RE: Chaparral Elementary School Portable Relocation
Grading and Drainage Plan
Engineer's Stamp Dated 4-14-15 (File: F10-D005)

Attached is the revised Grading and Drainage Plan sheet submitted for approval. The revisions have been performed based on your comments from the original submittal. Two hardcopy sets will be delivered to your office in addition to this electronic submittal.

SHEET NO:
 C-105R

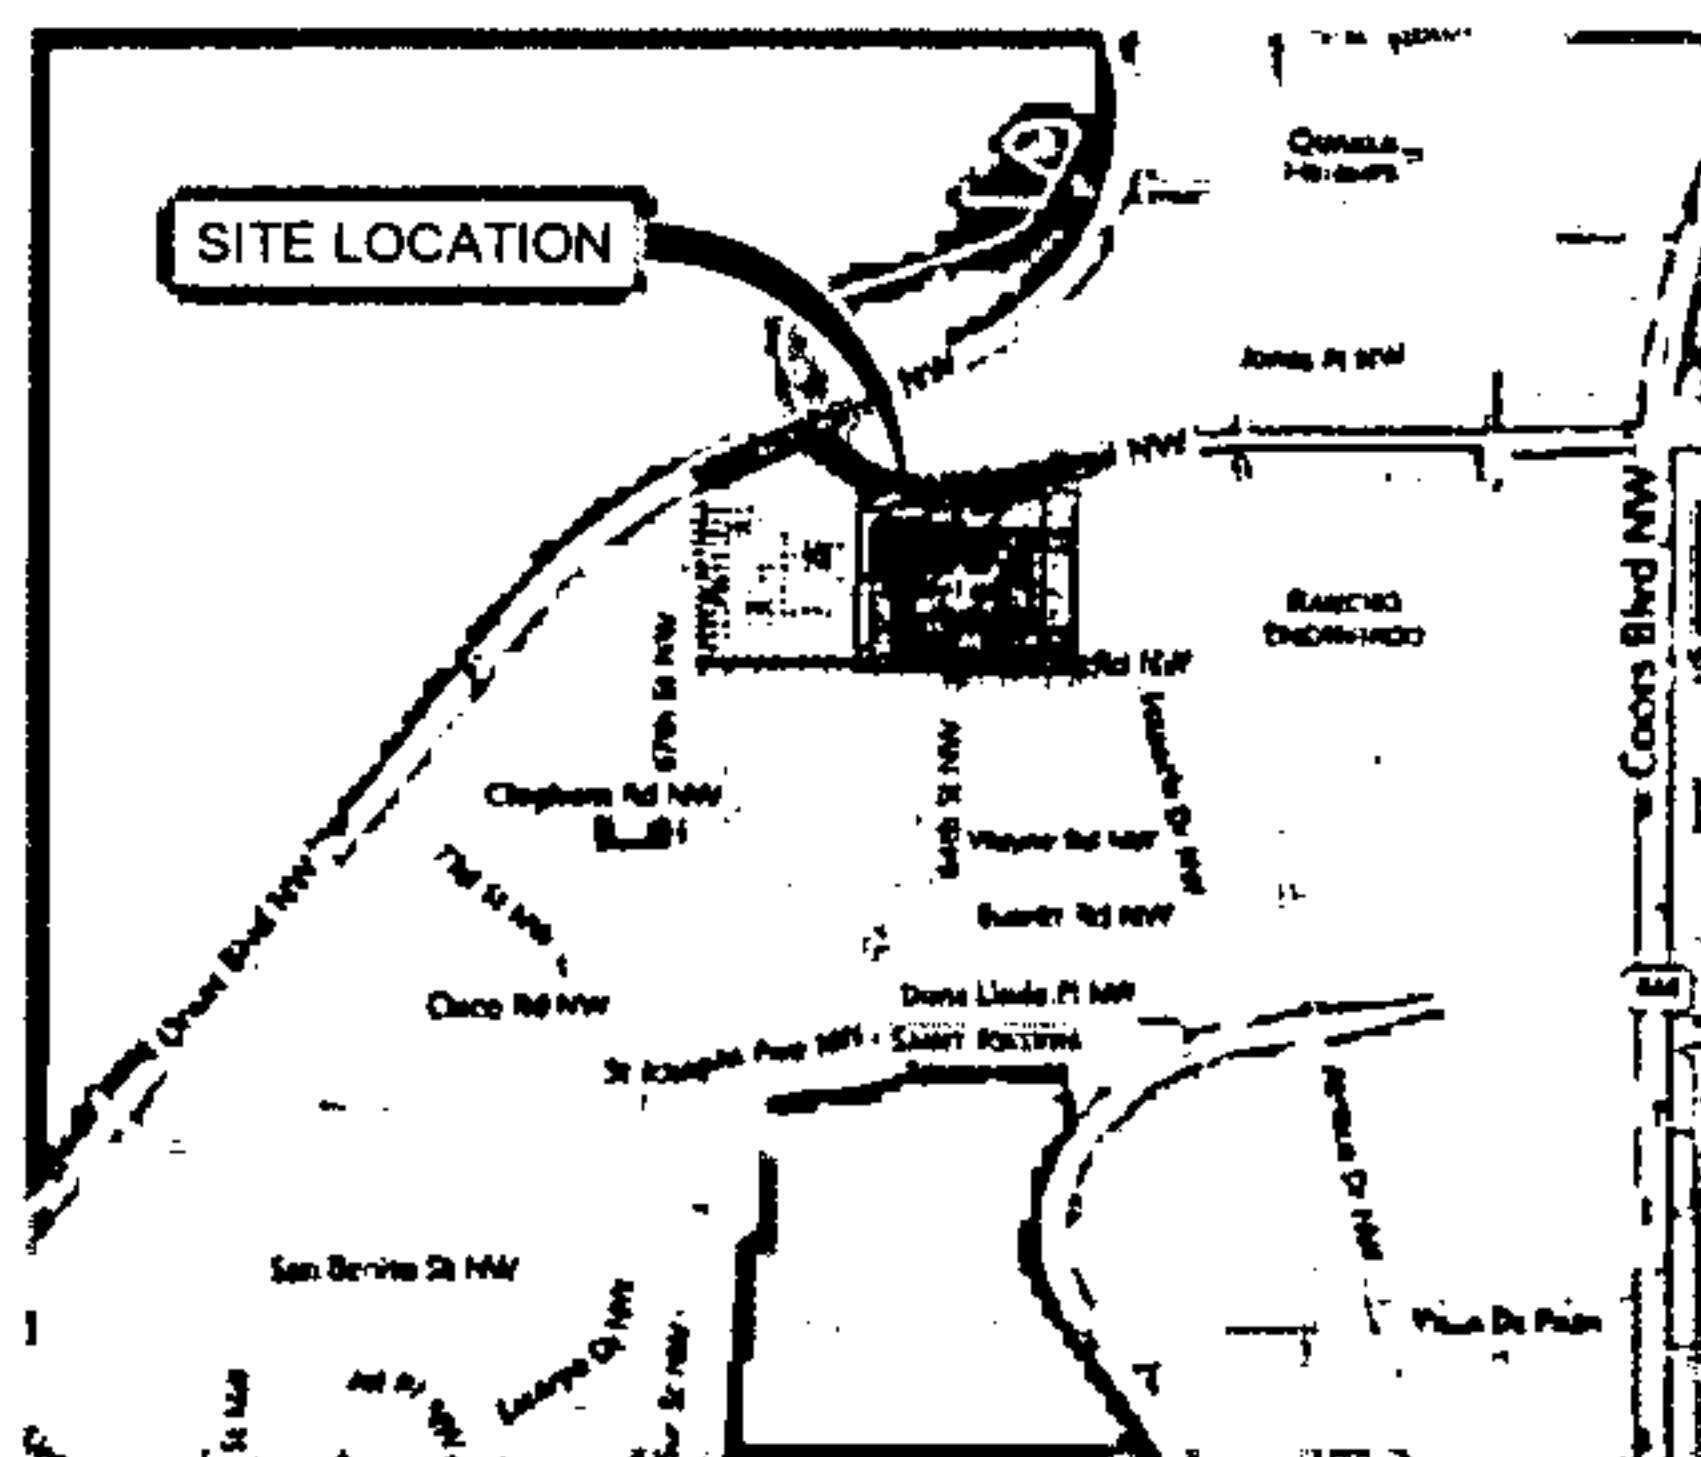
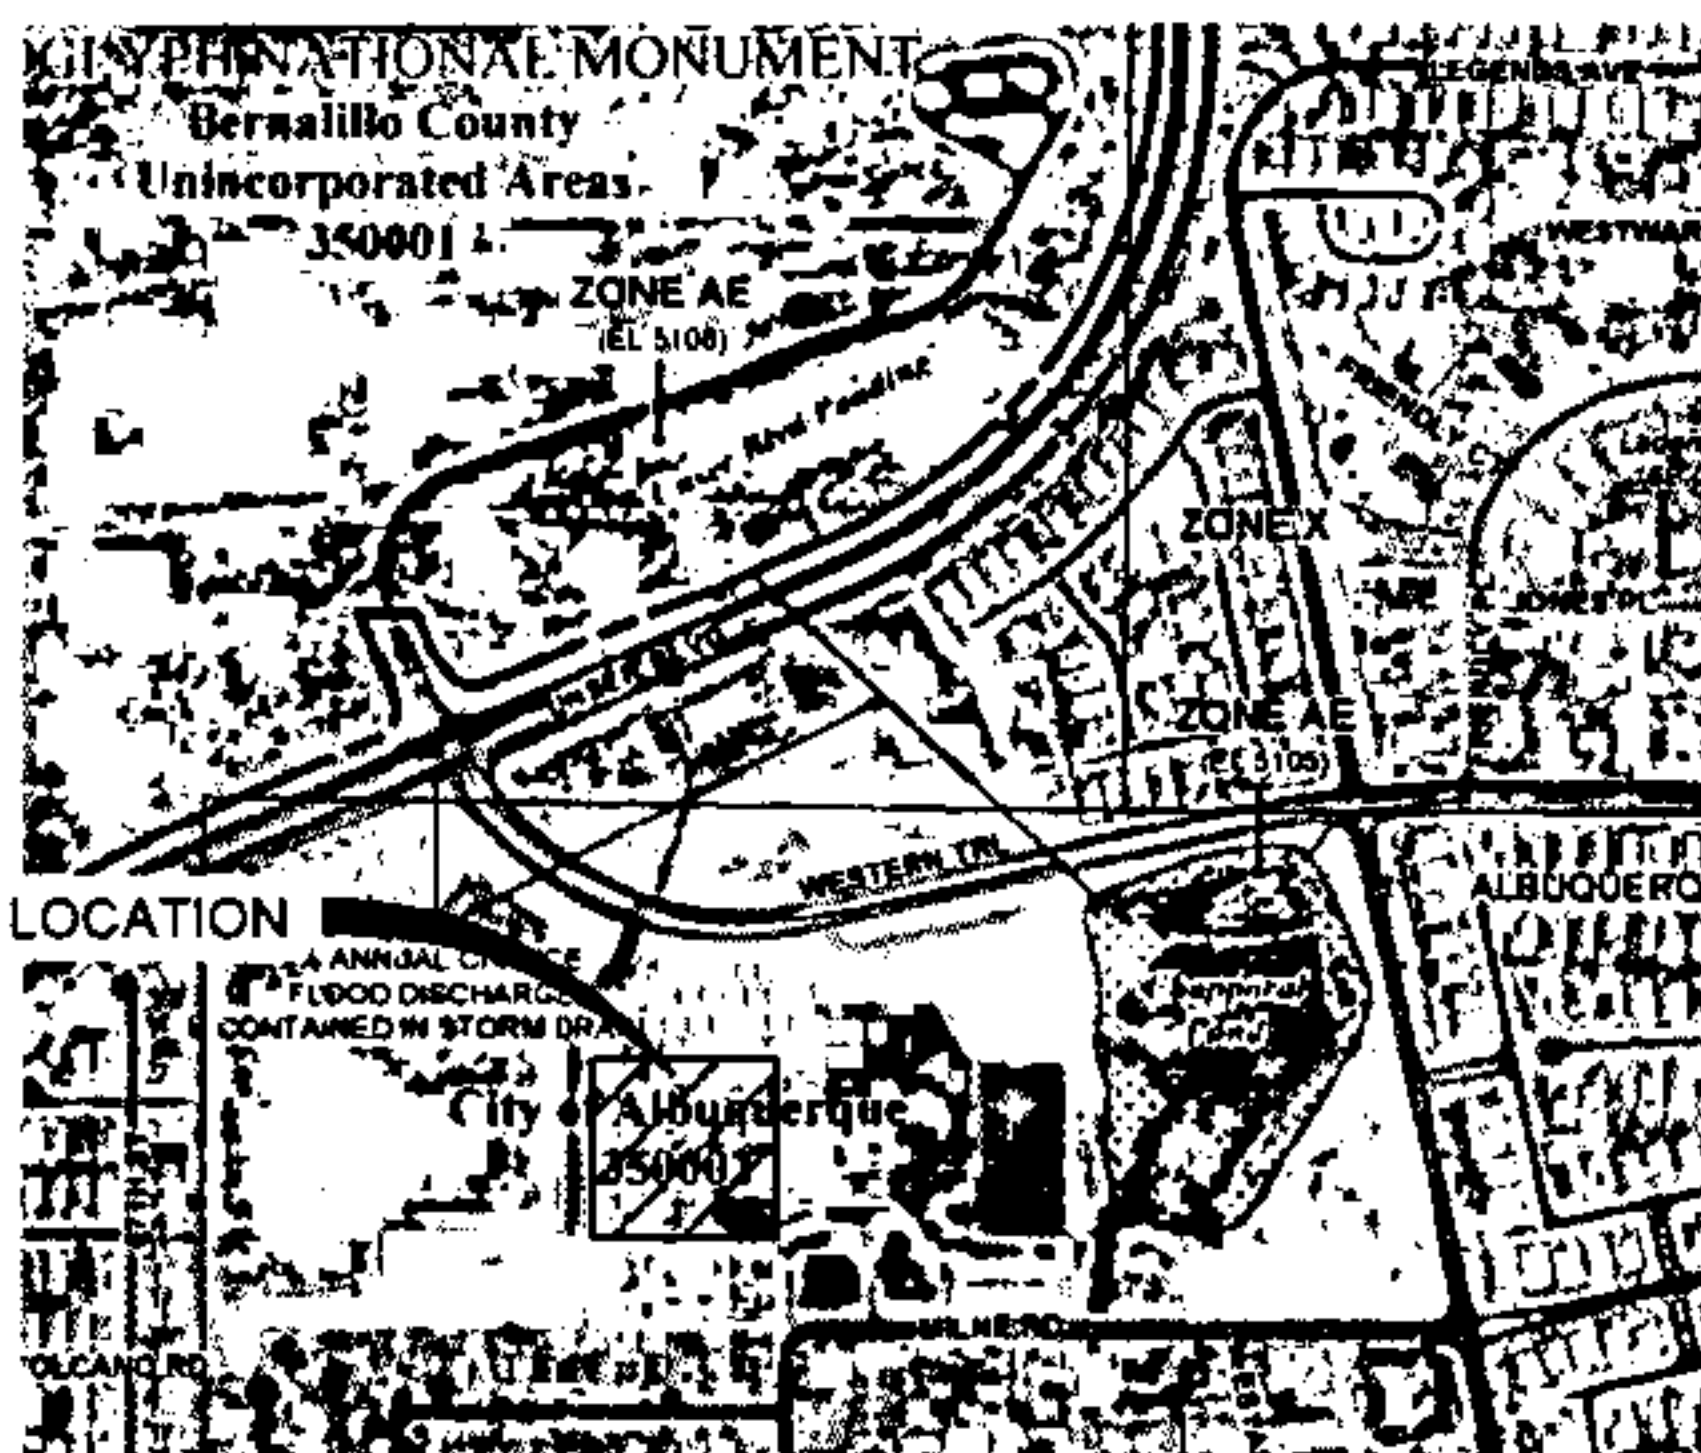
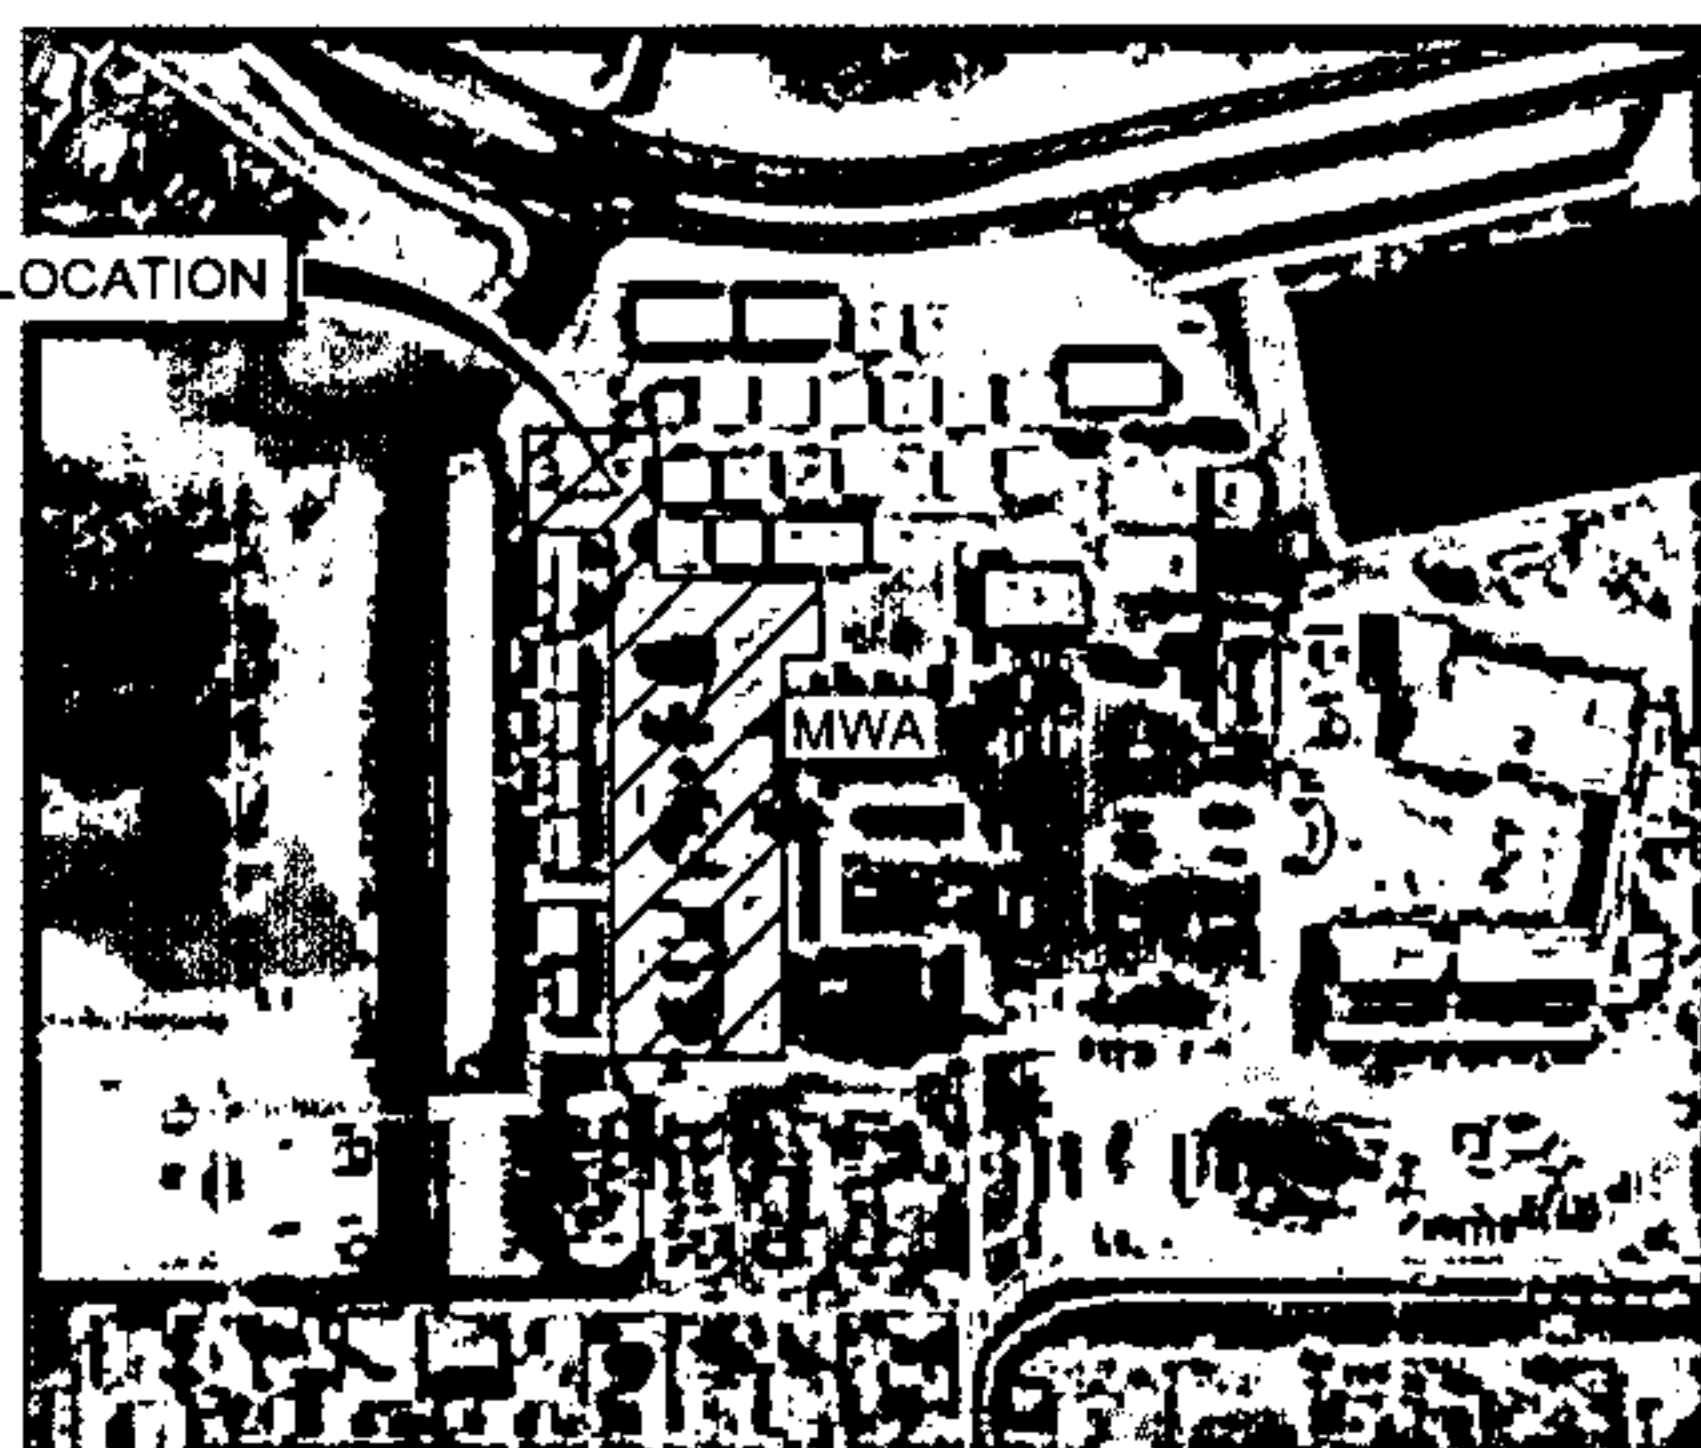
1. The first flush volume of 220 cubic feet will be conveyed to the Ladera Basin 16 sump which lies immediately east of the school site. The sump will allow any pollutants to settle out before entering the city storm drain system. The first flush computation have been included on the sheet.

2. Analysis points have been included at pipe inlets and sidewalk culverts. Calculations were also included showing the capacity of the proposed structures.

3. The existing 18" storm drain pipe has been labeled and a proposed 100-year discharge of 11.94 cfs is also labeled.
4. Additional flow arrows showing the direction of runoff from the roofs of the portable buildings have been included. Any flow on the west side of the portable buildings will flow north passed the portable building than east toward the proposed curb & gutter. The direction of discharge in Basin 4A within this project continues to follow existing drainage patterns. The increase in impervious area is accounted for in the plans to develop Basin 4A which will proceed following the completion of the portable relocation project. Refer to Chaparral Elementary School Addition Plans for Proposed Developments layouts.
